Application for Approval of Details Reserved by Condition

Proposed enlargement of Car Park B to create 15 additional designated parking bays;
Remove planting bed adjacent to existing disabled parking bay to provide two sideby-side disabled parking bays; Provision of three new cycle shelters, providing space for 18 bicycles along the main school entrance walkway.

3/2024/1020

Condition No.4 - Proposed landscaping
Condition No.5 - Landscape/habitat management and monitoring plan
Condition No.7 - Details of an alternative secure cycle storage

Project	
St Cecilia's RC High School, Longridge Additional Car Parking	
Title	
Location of New Trees within Sports Field	
Scale	1:500 @ A3
Date	11.09.25
Drwg No	4974 /P11
Drawn

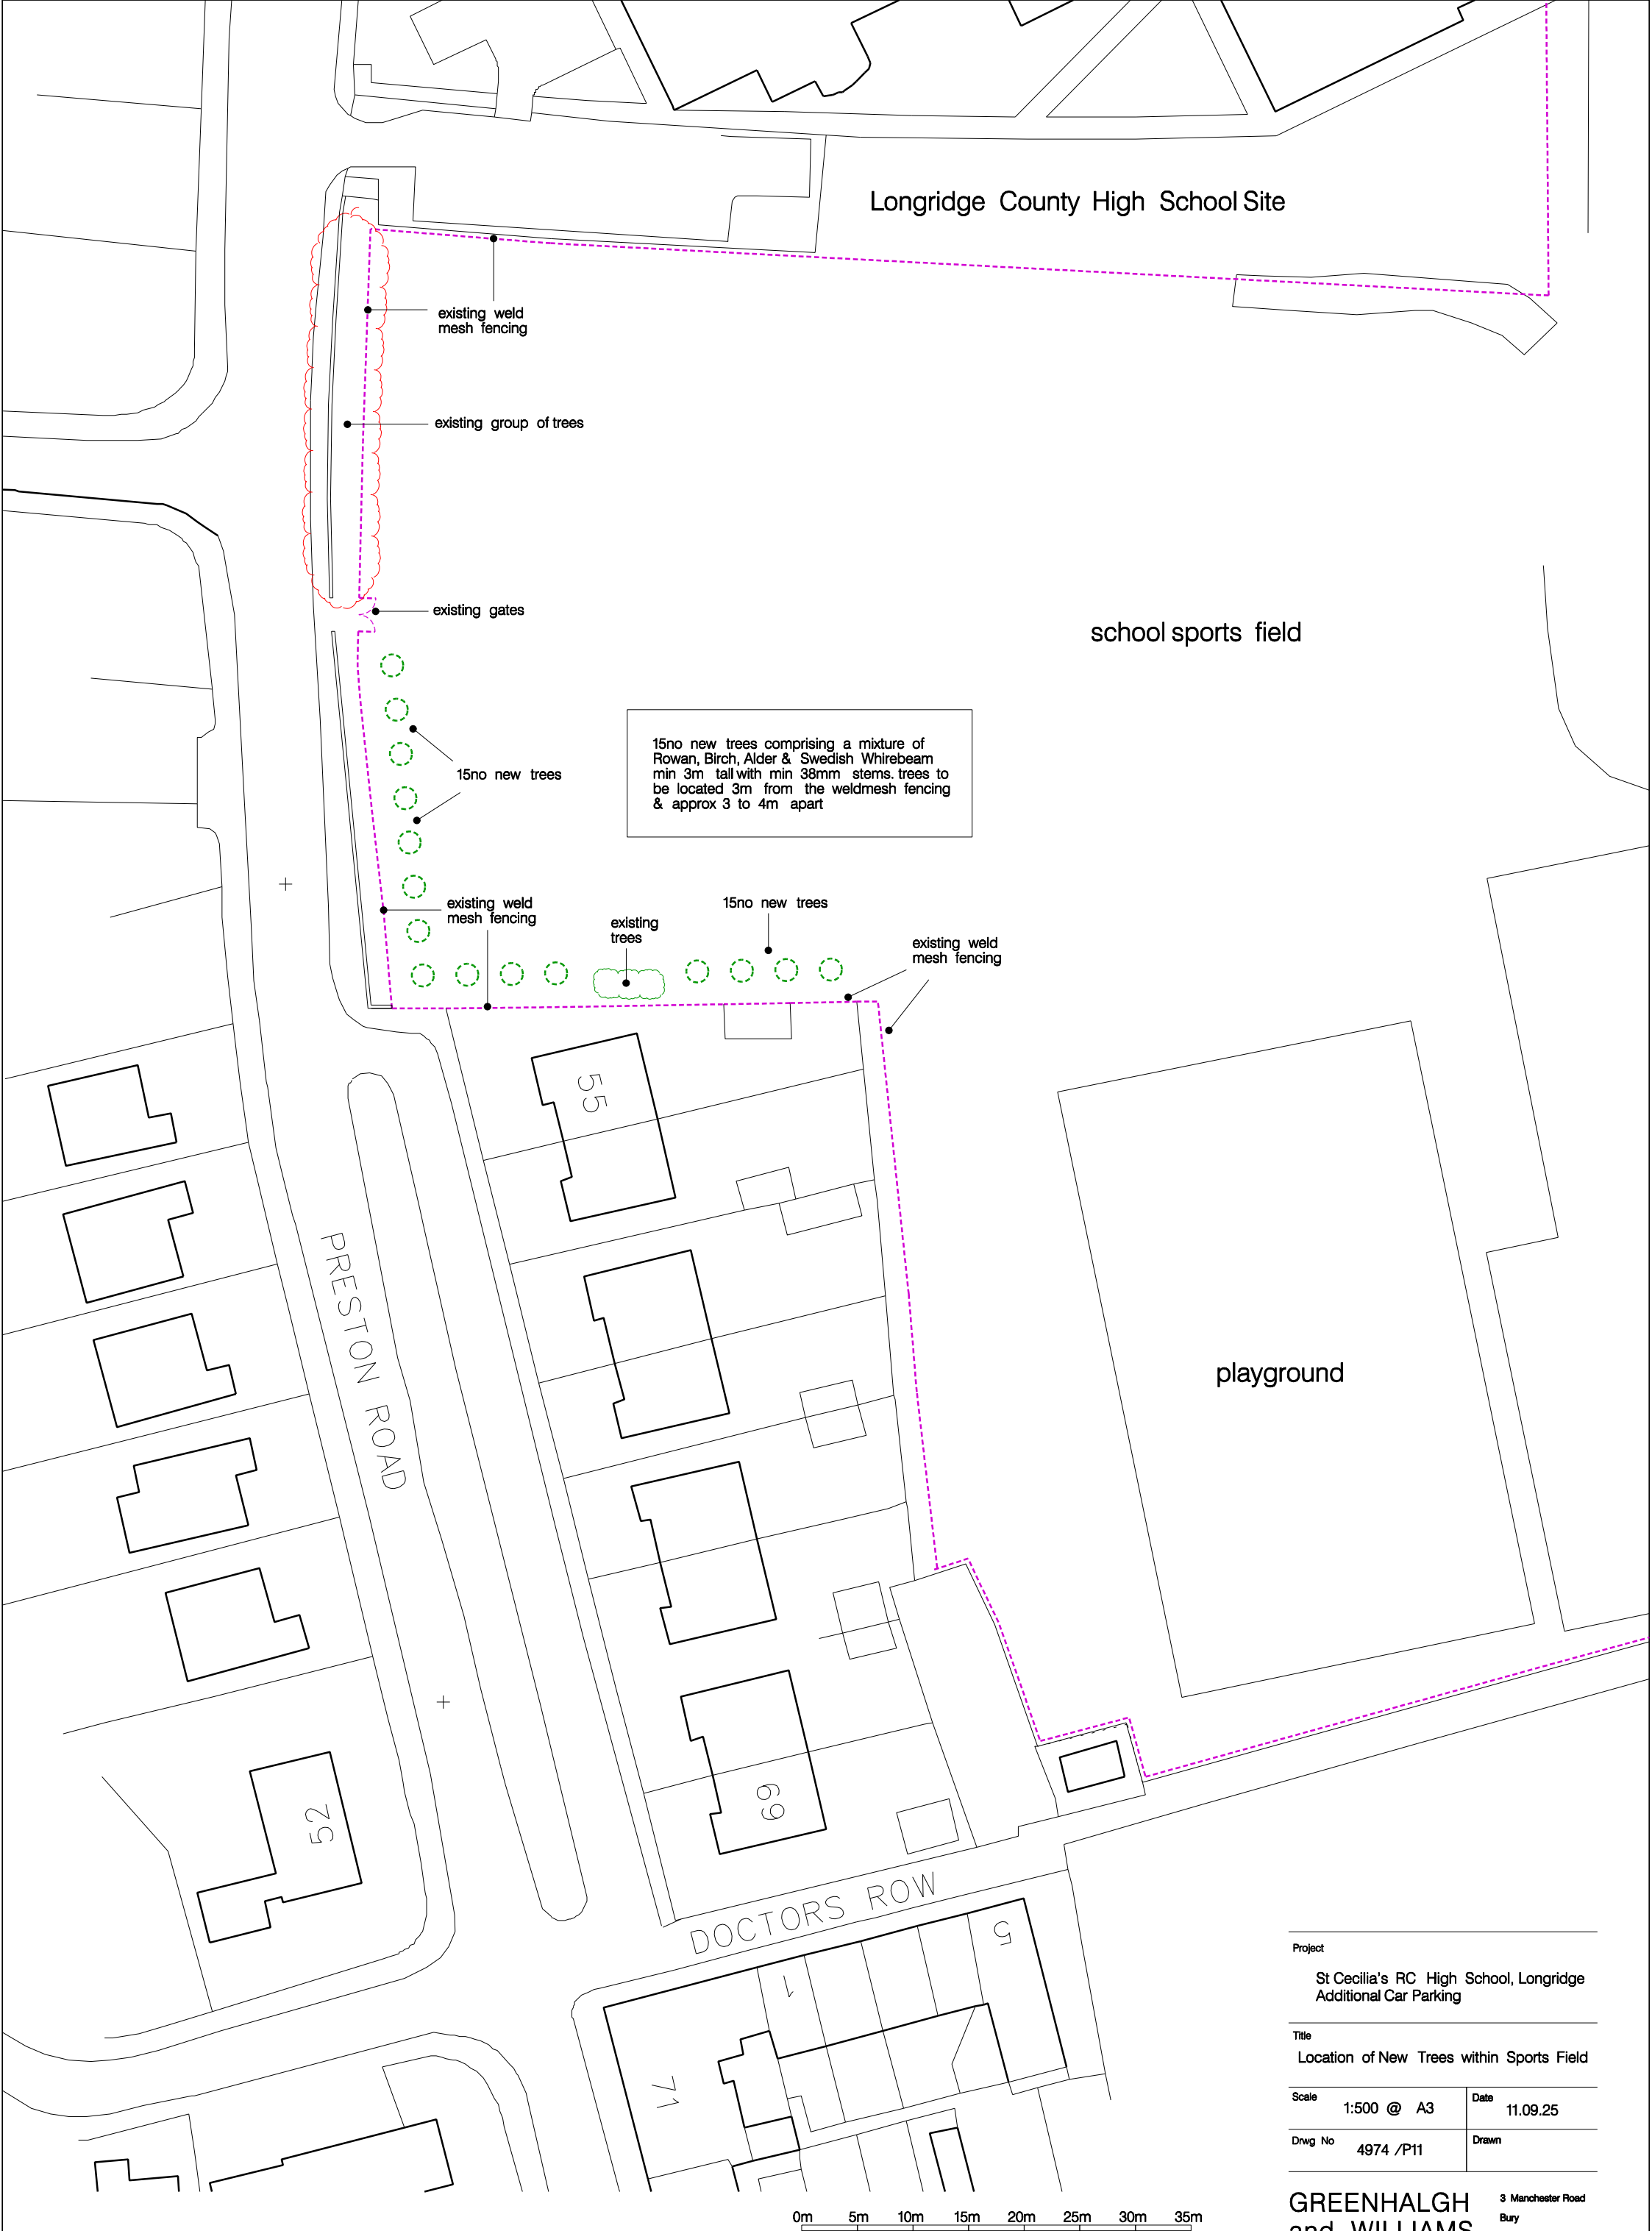
The planning authority consider that as the wildflower meadow would need to be left wild for the majority of the year its appearance will harm the character of the site and surrounding area and as such an alternative landscaping scheme has been prepared.

In consultation with the appointed ecological consultant the school has decided to meet the BNG requirement by planting 12no. trees in addition to the 3no. already in the scheme. The location of the new trees is to be along the western boundary of the school playing field adjacent to Preston Road and north of the residential properties. The trees are to be set 3m in from the perimeter mesh fencing and 3 to 4m apart. The new trees are to be approximately 3m tall with a minimum 38mm stem. The area surrounding the new extended car park will revert to mown lawn.

The location of the new trees is identified on drawing 4974/P11. Further supporting details are contained within the attached 'Tree & Shrub Planting Management & Monitoring Plan' prepared by Greenbanks Arboriculture Ltd.

Project			
St Cecilia's RC High School Longridge			
Title			
Proposed Cycle Shelters			
Scale	1:20 @ A3	Date	23.09.25
Drwg No	4974 /P12	Drawn	
GREENHALGH and WILLIAMS		3 Manchester Road Bury BL9 0DR Architects and Building Surveyors Tel : 0161 764 6995

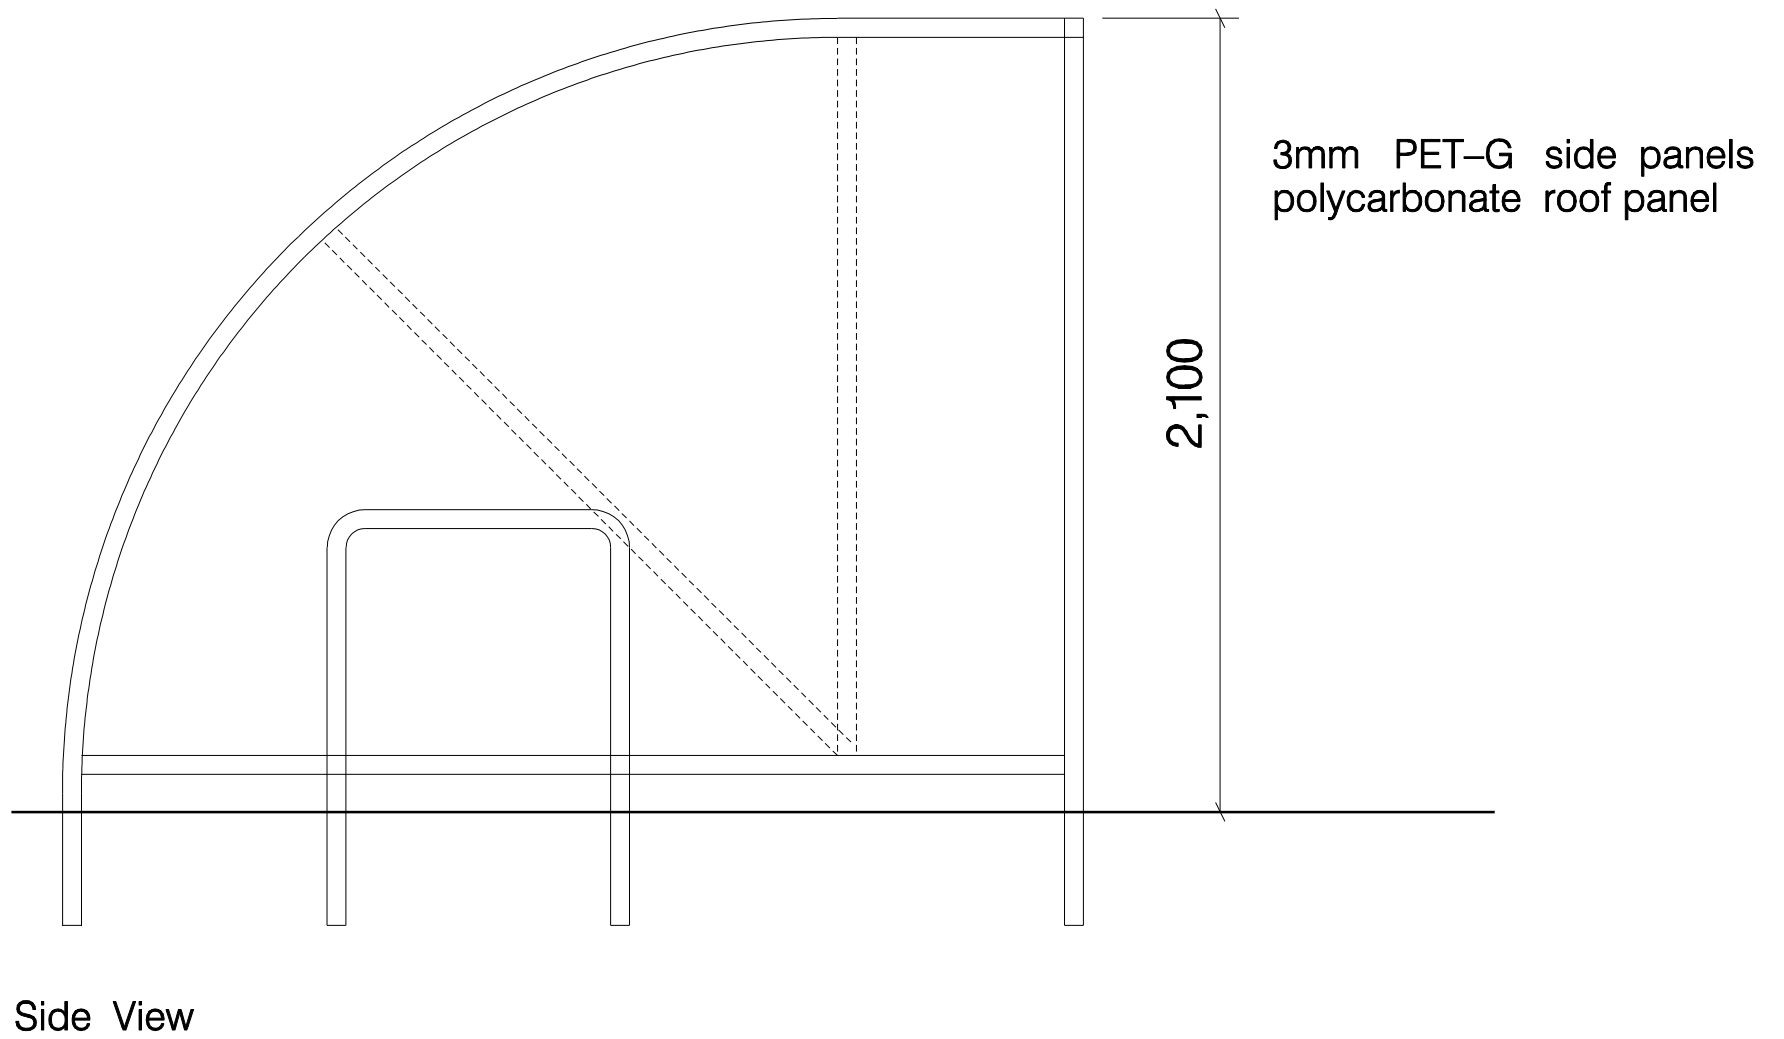
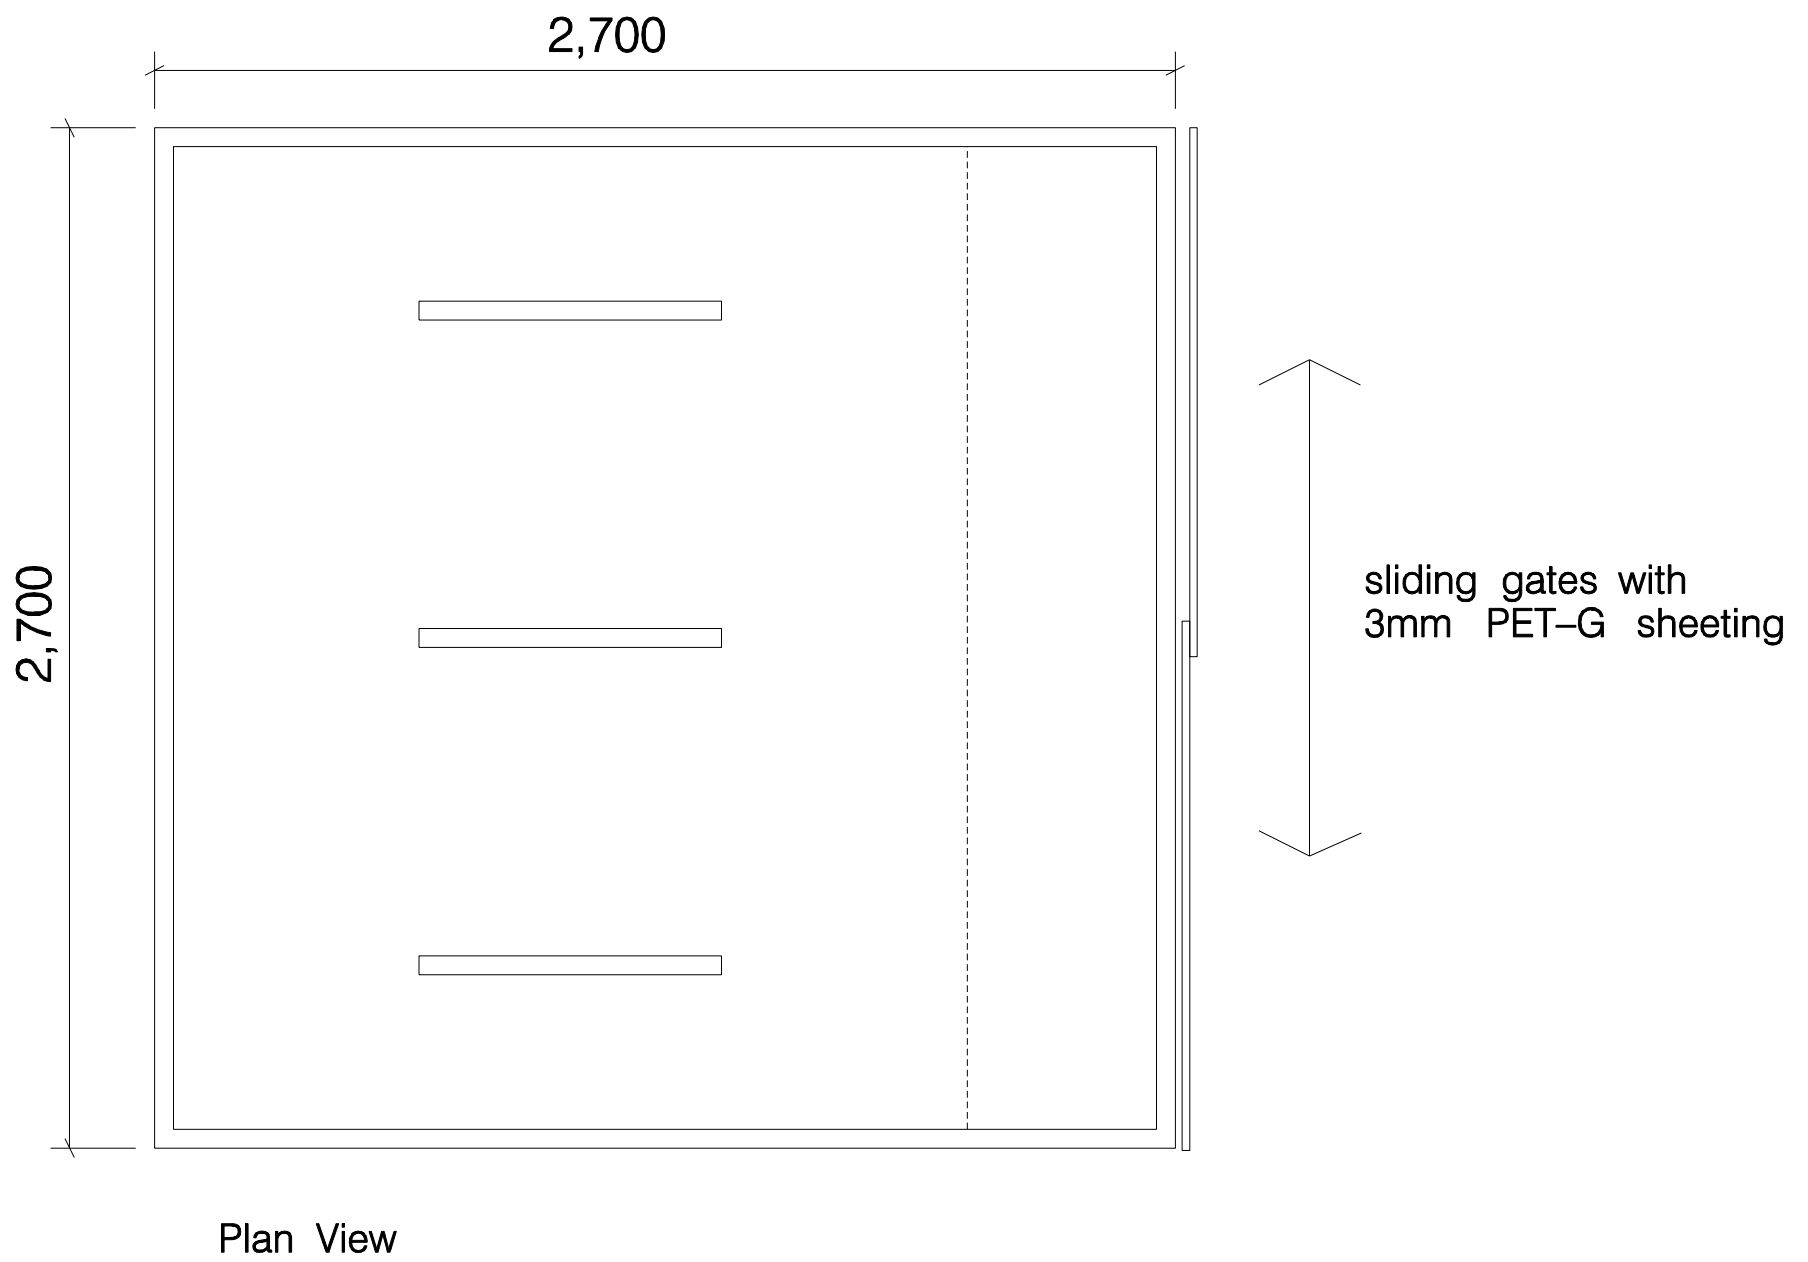
The planners are concerned that the bicycles will not be well protected from the weather during the winter months. To address this, we have enlarged the cycle shelters and introduced sliding lockable gates with Pet-g panels. Please see attached drawing 4974/P12.
